**Christina Stacey - Fwd: Permit #2297 - 34 Sterling St.**

**From:** harvey johnson <harvey.rachelconlydesign@gmail.com>  
**To:** <cstacey@portlandmaine.gov>  
**Date:** 10/6/2015 1:32 PM  
**Subject:** Fwd: Permit #2297 - 34 Sterling St.  
**CC:** Rachel Conly <rachelconlydesign@gmail.com>  
**Attachments:** A2 Proposed Site Plan.pdf

A2
Proposed Site Plan

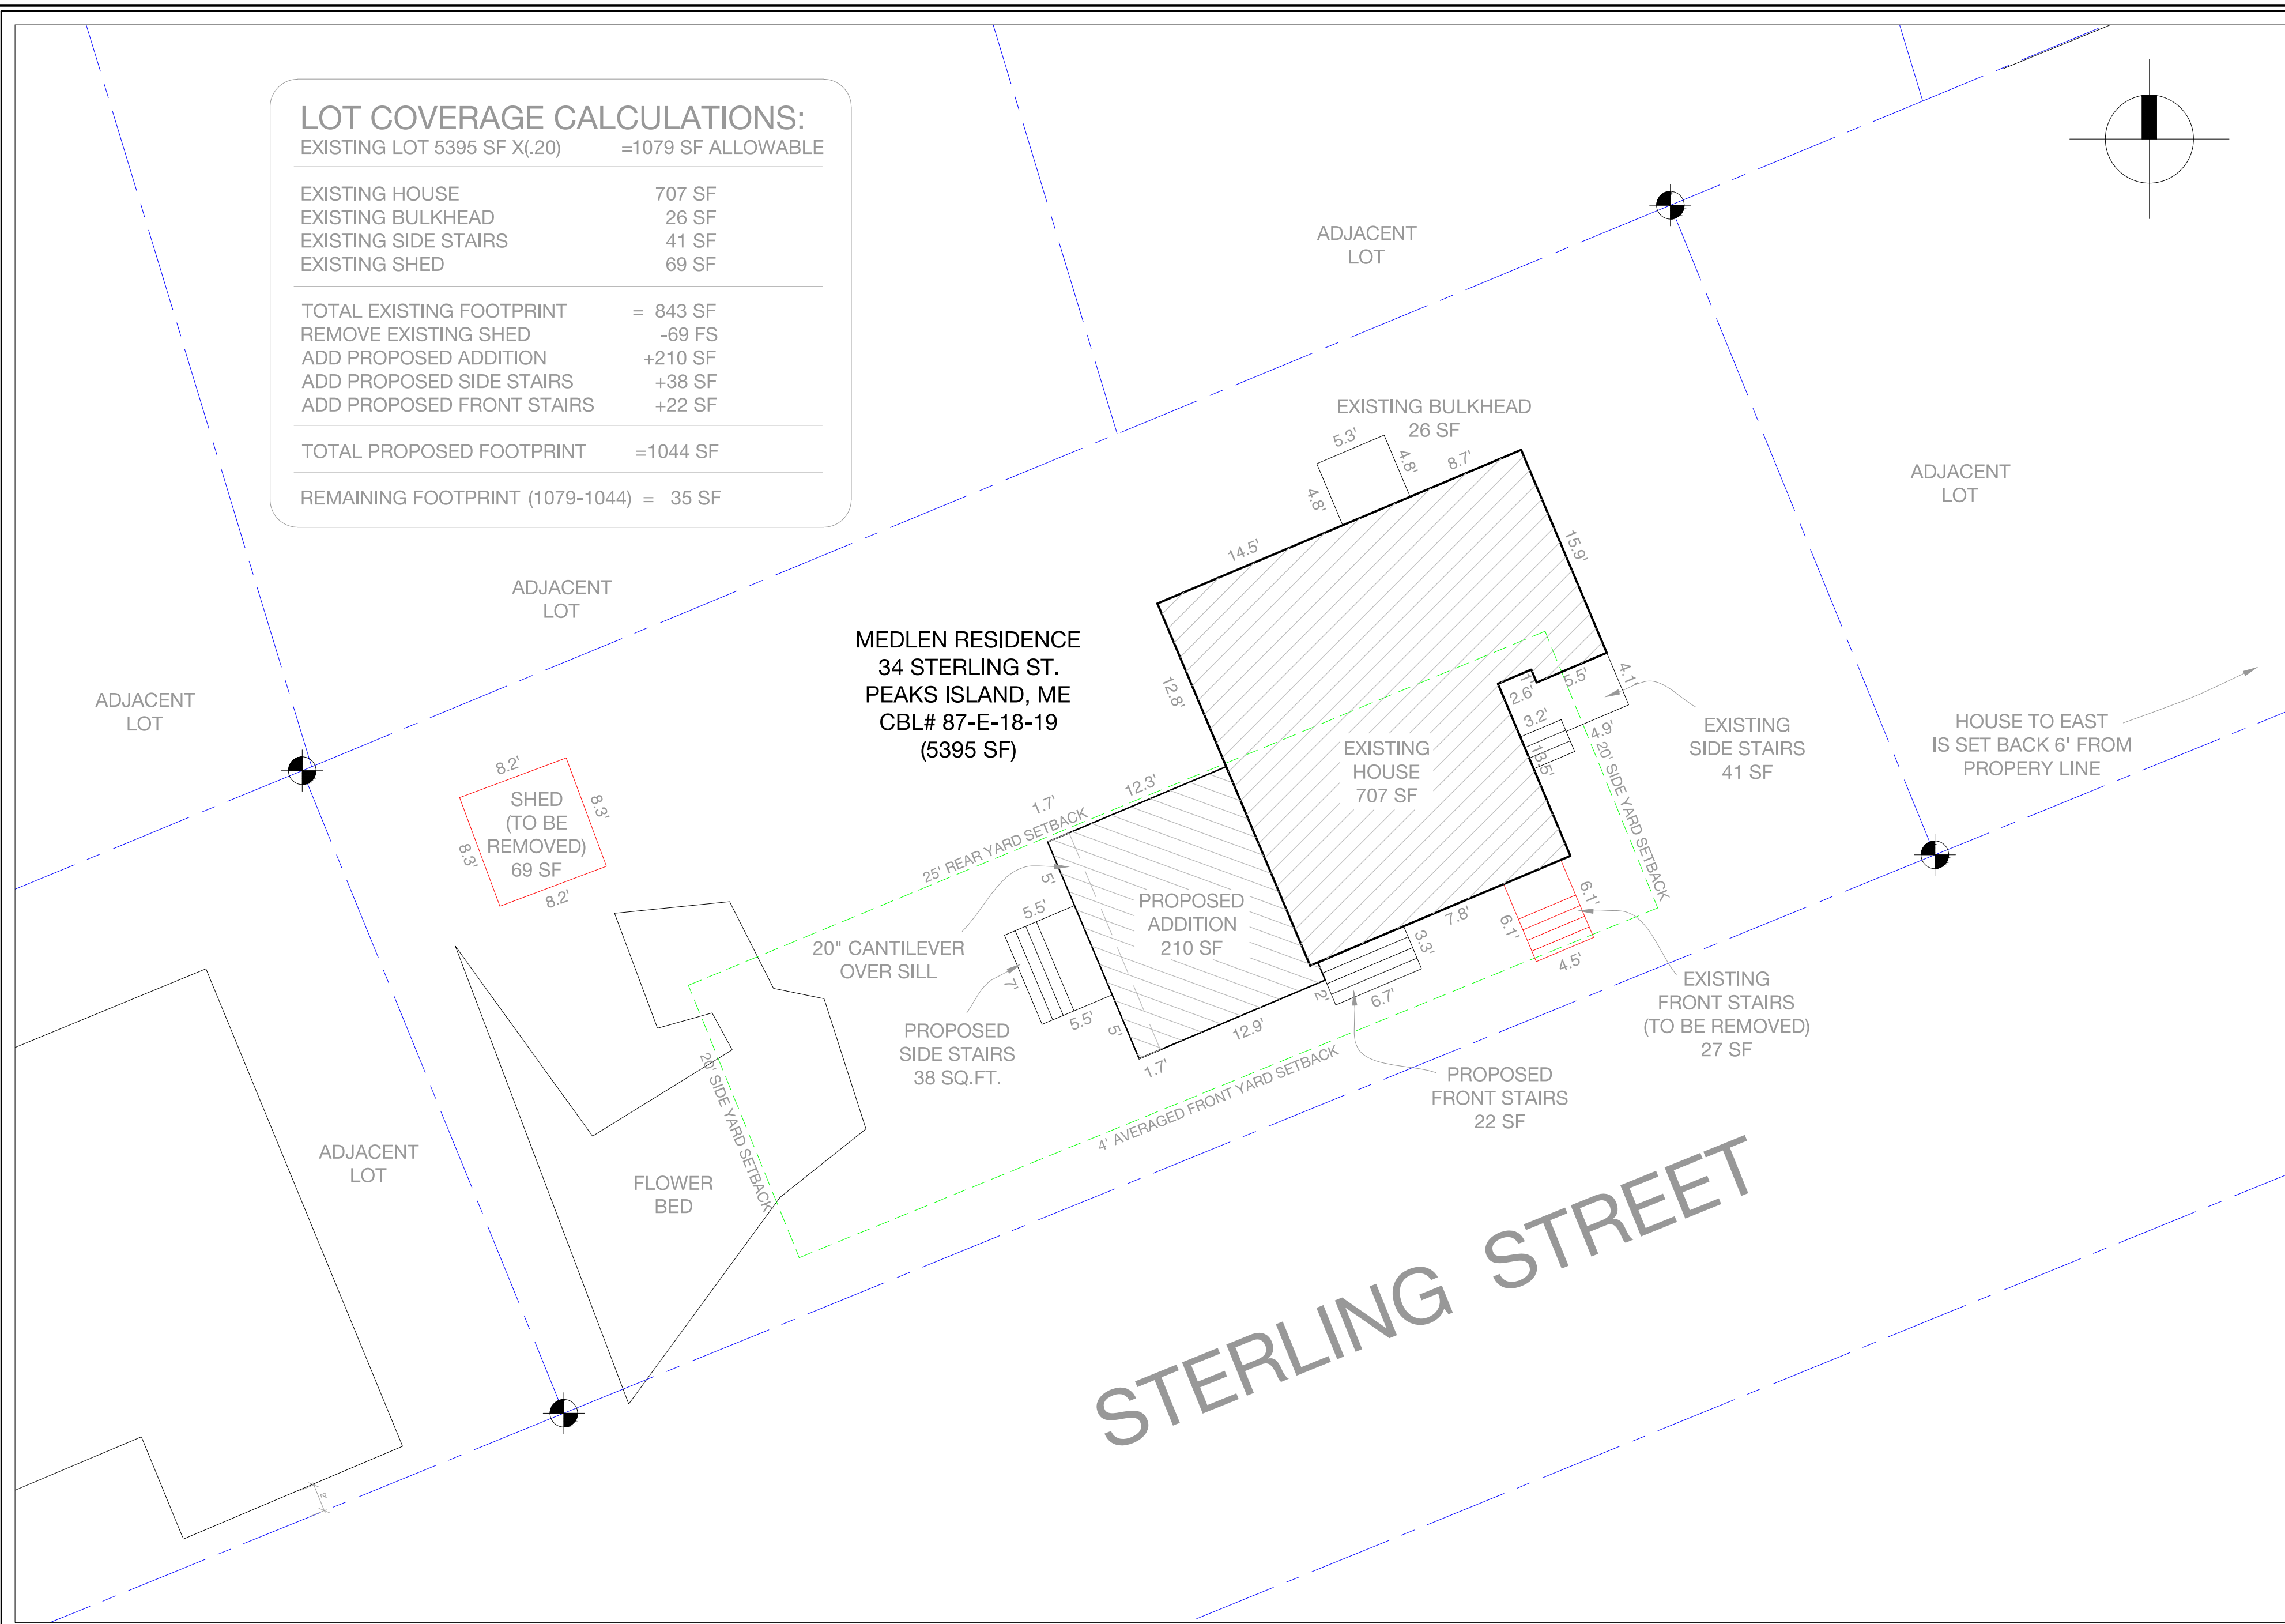
I'm currently reviewing the application for an addition at the above-referenced address. I do not think the project as proposed will meet the lot coverage requirements. The primary issue is that you do not get a "free" 50 sq feet of entry steps using Section 14-425 as noted on the plan. This section only applies to the construction of entry stairs in "required yard areas" - i.e. within the minimum setback area. This is to provide a the steps/landings needed for a door that's in a legally nonconforming location. The structure would still count towards the lot coverage calculation.

Based on your plan, here are the figures I came up with:

Existing house - 695.3 sf

Existing side stairs - 40.9 sf

Existing bulkhead - 25.4 sf

New front stairs - 22.1 sf

New addition - 238.8 sf

New side stairs - 38.5 sf

Existing shed - 68.1 sf

TOTAL - 1,128.1 sf > 1,079 sf allowed

Also, on the provided site plan, it appears that the green front yard setback line isn't drawn in the right location - it appears to measure about 4' from the front lot line rather than the 6' it states.

Thank you for your comments, and follow up. Please see the revised siteplan, attached.

In order to get the lot coverage below 20%, we have opted to remove the existing shed.

Sorry for the error with the front yard setback. We double checked the location of the neighbors' houses, and it turns out that I had mislabeled the setback line. It should have read just as it measured, at 4'.

Also, I noticed that our lot coverage calculations differed from yours. As we have done in previous projects (see permit I.D. # 2014-01531), in order to conserve footprint, we are proposing a 20" cantilever of the floor framing (at the sill), as permitted by section 14-425. This will allow us to measure to the footprint of the foundation for lot coverage calculations, versus to the envelope of the addition. I have revised the dimension labeling to show this overhang a little more clearly. For reference, the overhanging can be see on page A11, the South Elevation.
